PLANNING AMENDMENT

H09/0787/00

REPLACEMENT BUNGALOW

**RE: PROPOSED REPLACEMENT BUNGALOW AT THE BUNGALOW ROMAN BANK
HOLBEACH BANK FOR MR G A SMURTHWAITE**

project
CAM-S
PLAN

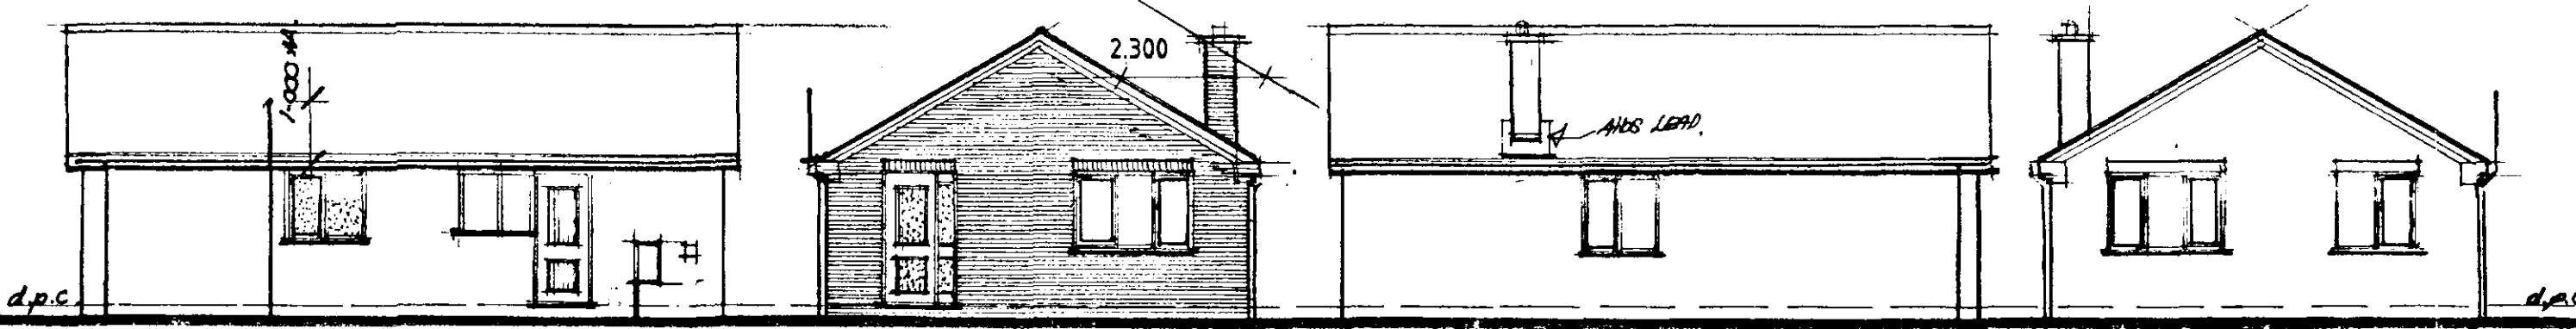
SOLDIER COURSES ADDED
ABOVE WINDOWS TO GARLEND

The elevations have been changed on the above to show soldier courses above windows to the gable end.

Please note that the facing bricks should read Ibstock Oxton Red Multi.
